REQUEST

The petition proposes to allow a maximum 2.5 million square foot data center and an electric substation on acreage located at the southeast quadrant of University City Boulevard and Interstate 485 in northeast Charlotte.

PLANNING STAFF REVIEW

RZ-1.0

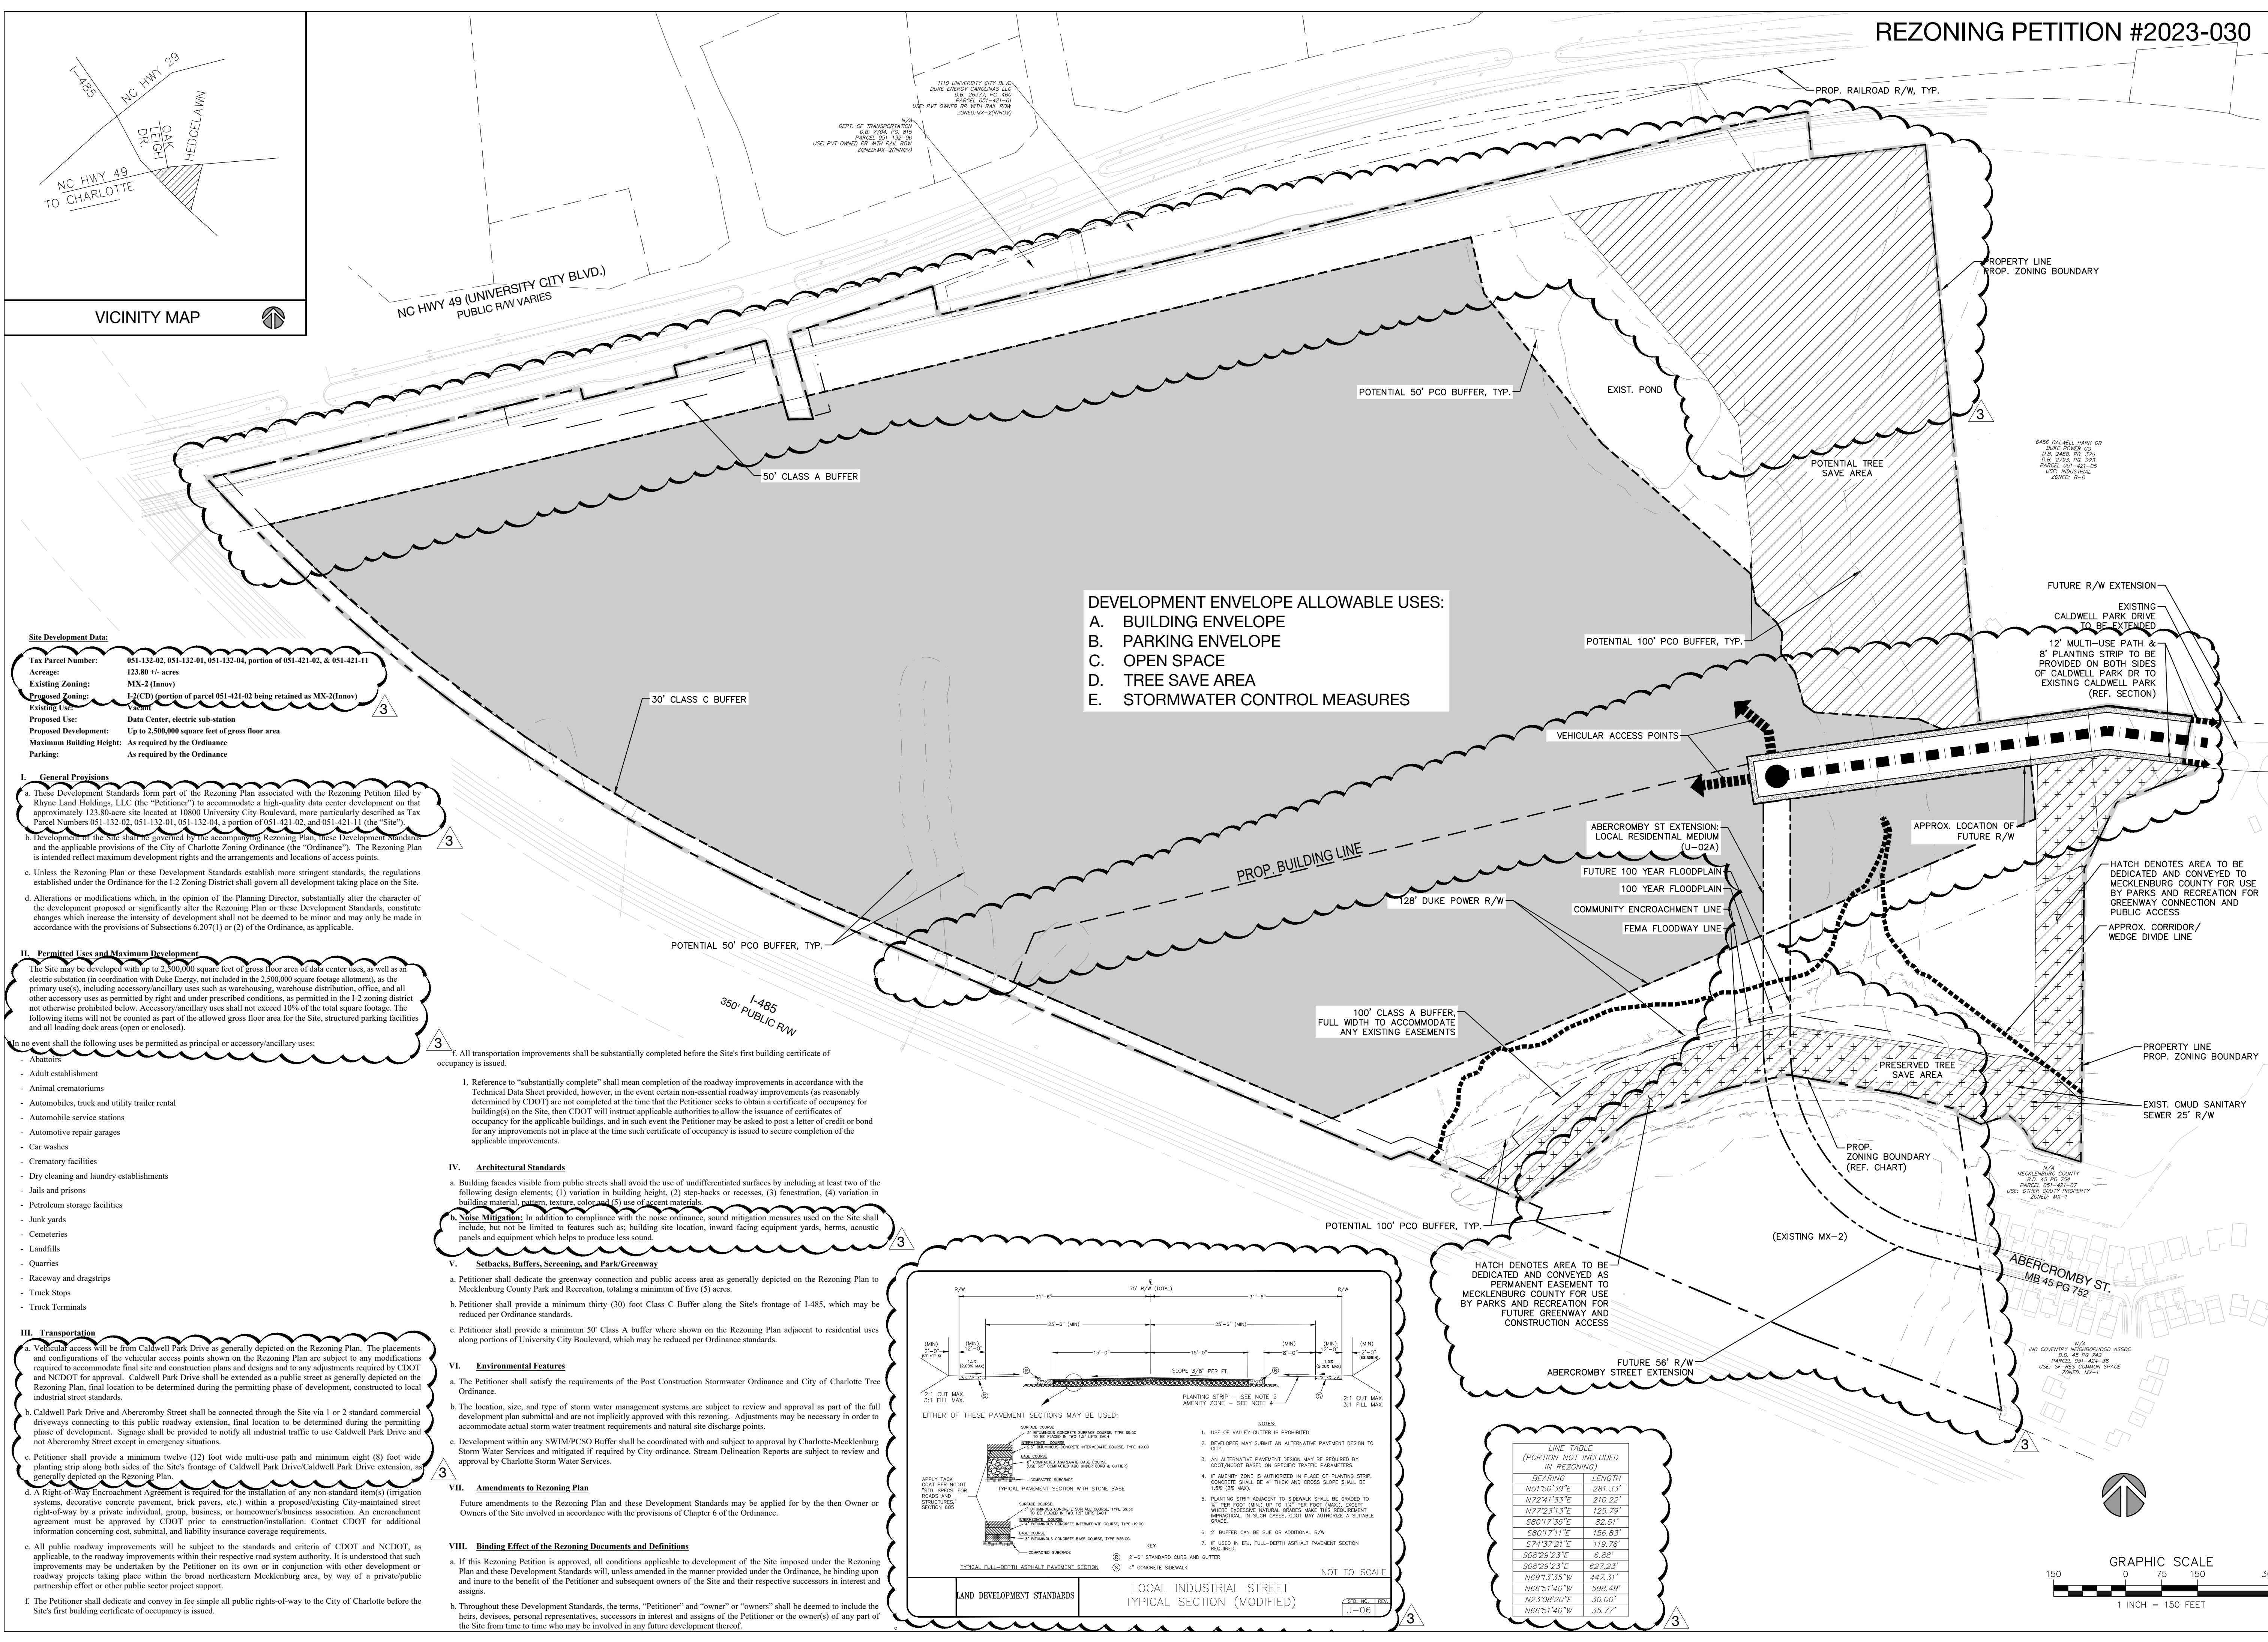
- ~~1. Revise site plan and conditional notes to connect Abercromby Street to Caldwell Park Drive. Site access shall be via 1 or 2 standard commercial driveways connecting to this roadway extension. Site plan shall commit to installing signage for all industrial traffic to use Caldwell Park Drive and not Abercromby Street.~~

- 2.—Add conditional note that petitioner shall construct bicycle facilities by installing a 12' multi-use path with an 8' minimum planting strip along Caldwell Park Drive. The proposed multiuse path should be extended along the southern side of Caldwell Park Drive to the northwest corner of Parcel ID 05114117 owned by Mecklenburg County.

Clarifying Comment 6.21.2023: Label and dimension streetscape elements (12' multi-used path and 8' planting strip) along Caldwell Park Drive/Caldwell Park Drive extension.

Clarifying Comment 7.28.2023: 12-foot multi-use path shall be placed on both sides of the Caldwell Park Drive extension.

3. Provide a more defined location of buildings proposed on the site, particularly those adjacent to the single family residential uses to the south. **Illustrates a proposed building line.**
4. Provide a berm as part of the 100' buffer to provide additional separation and screening from single family residential uses to the south. Petitioner Response: **A berm would require trees to be removed and may cause more harm than good. Per discussions with staff, the petitioner removed the word "potential" from tree save, so this will be tree save area and no berm is necessary.**
5. Provide clarification on any proposed mitigation for sound impacts associated with the data center use. **Language pertaining to noise mitigation has been added to the language.**
